From: Emma Tristram [REDACTED]
Sent: 20 January 2018 09:48
To: Ross Leal
Subject: WA/84/17/PL

Objection to the renewed application for Fairmeads Farm, Binsted (WA/84/17/PL).

Title Proposed Agricultural building for secure storage of farm machinery, hay and straw at Fairmead Farm Binsted lane Binsted Arundel BN18 0LQ		Client Deborah Osborne Blackmill Cottage Blackmill Lane Norton Chichester West Sussex PO18 0JU
Scale 1:500	Date 27/11/17	Draw No RA/674/500 .IC Block plan

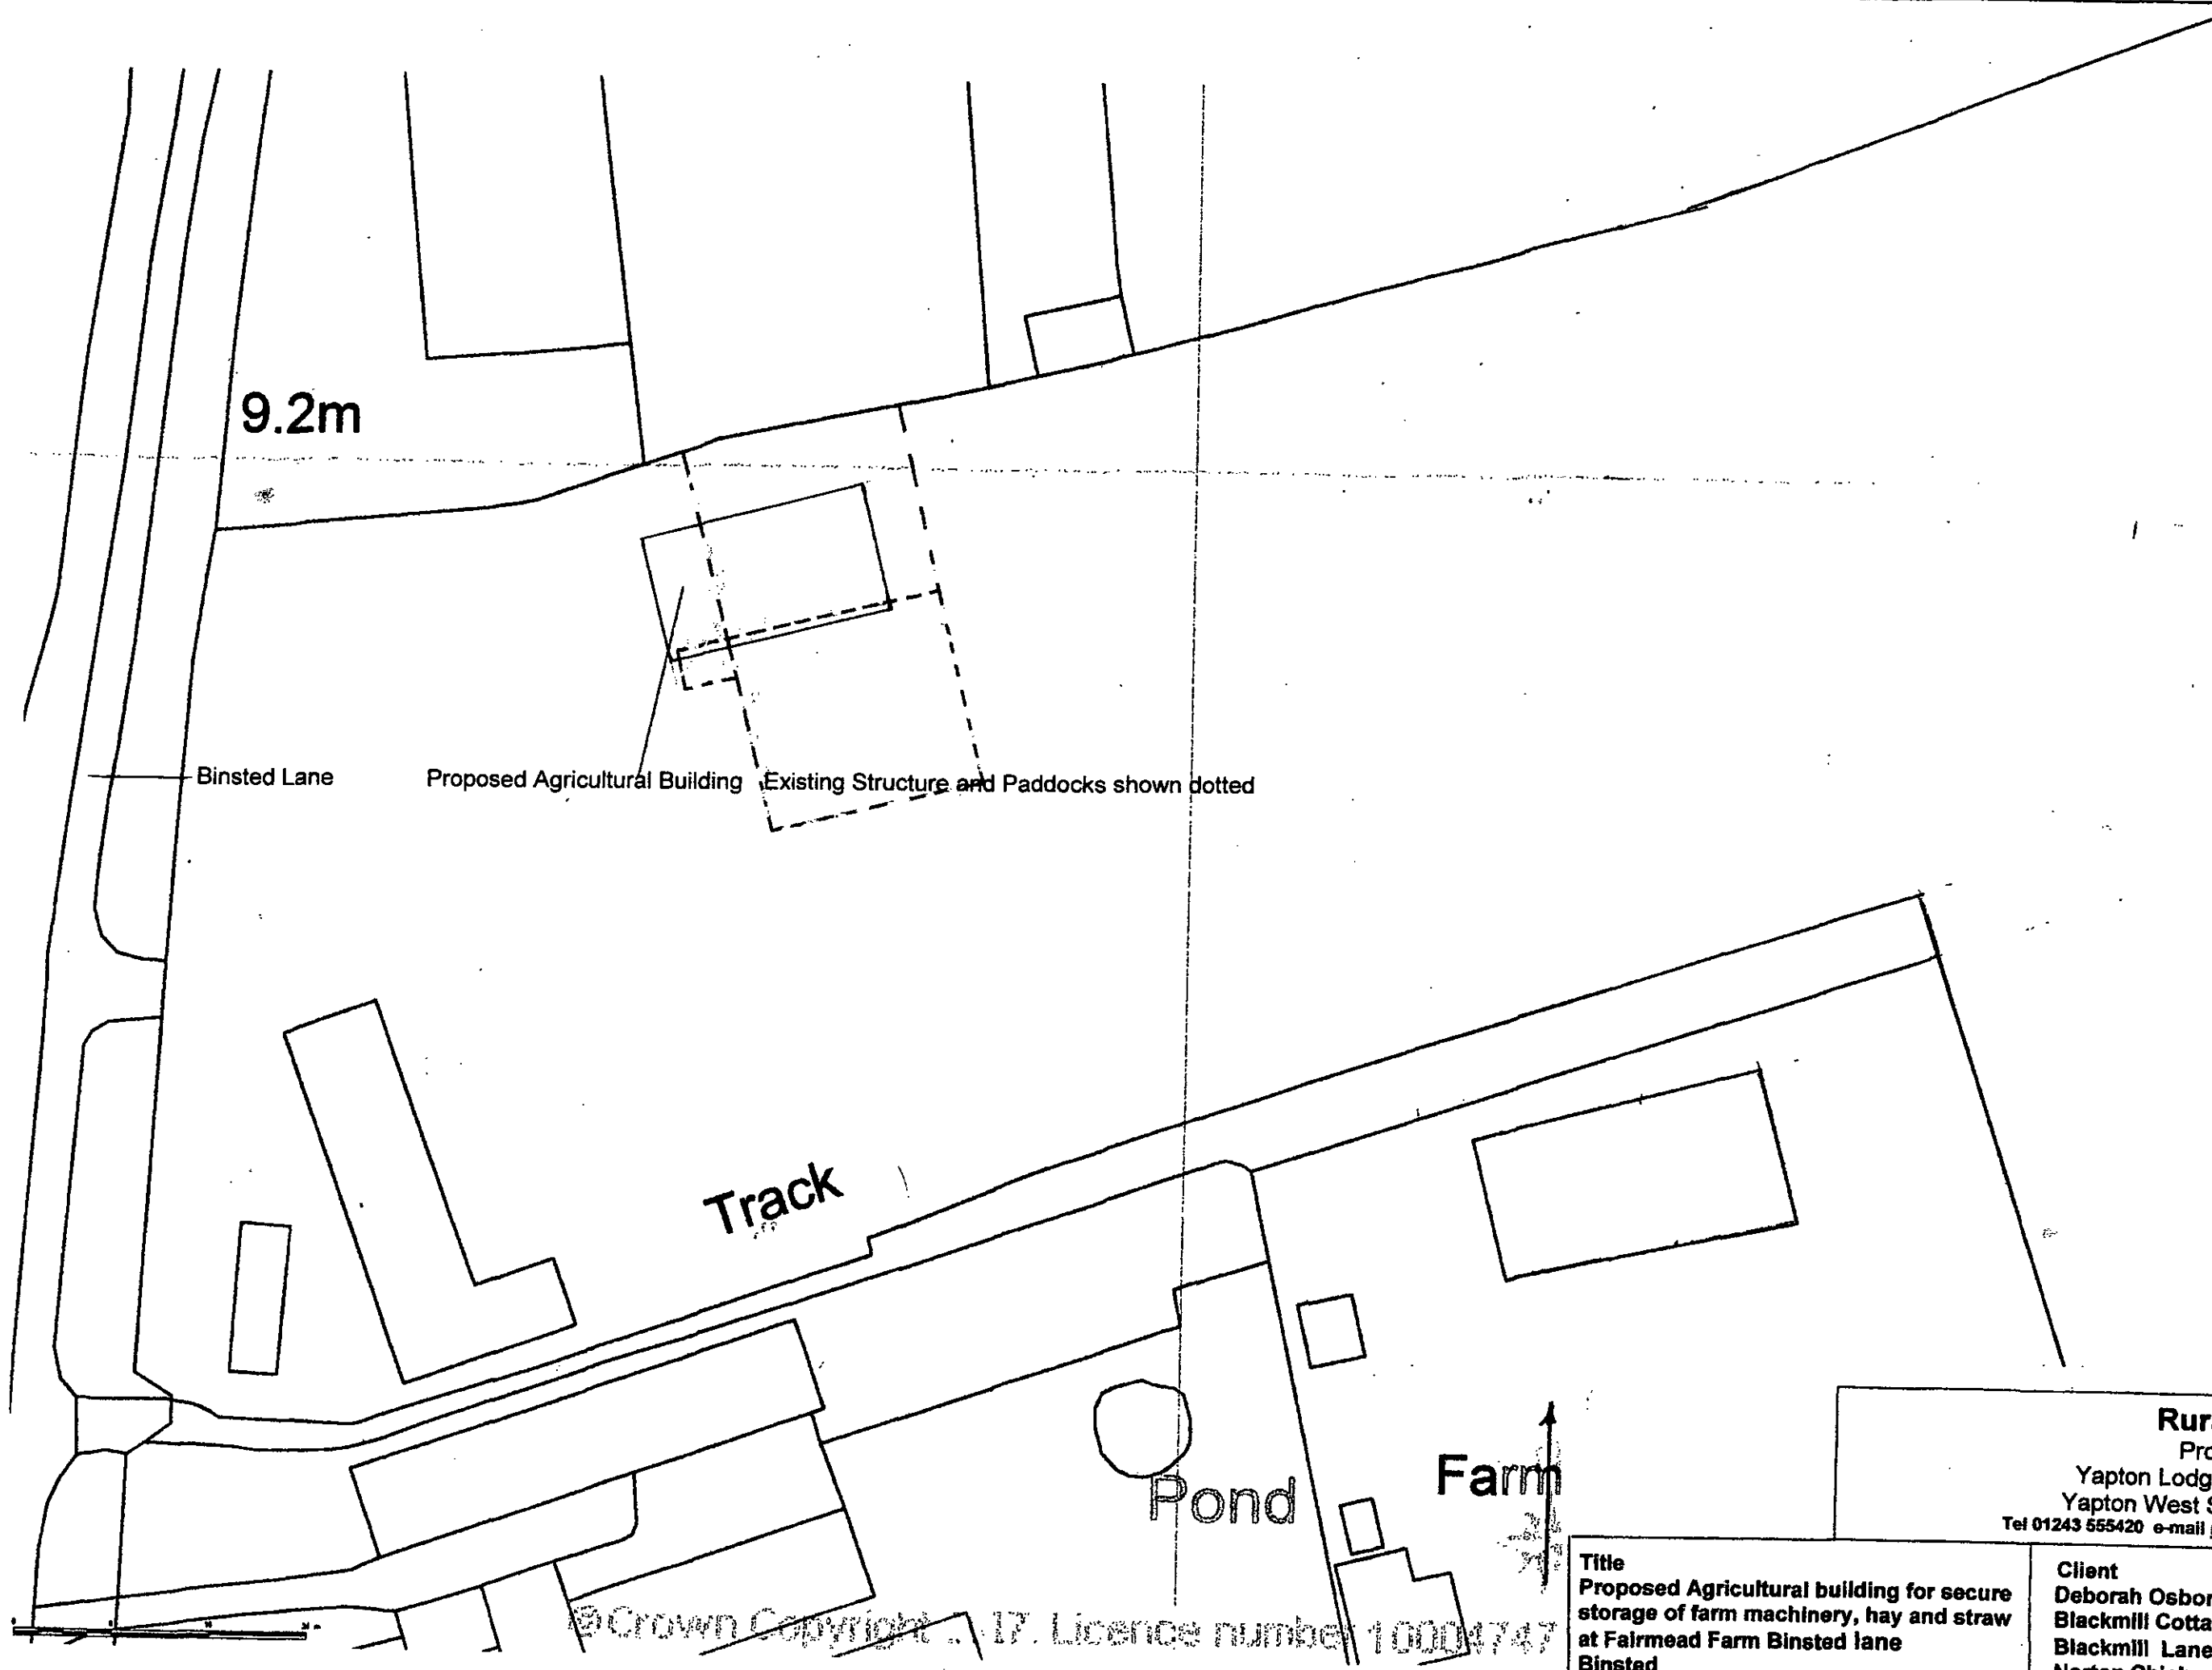
- On the site location plan RA/670/120, the red line is not keyed.
- On the Block Plan, RA/671/500, dotted lines are keyed 'existing structure and paddocks shown dotted'. As dotted lines are used for both, it is not clear which is 'existing structure' and which is 'paddocks'. If the larger dotted line area is assumed to show 'existing structure' this suggests erroneously that the new structure is smaller than what is there already.
-
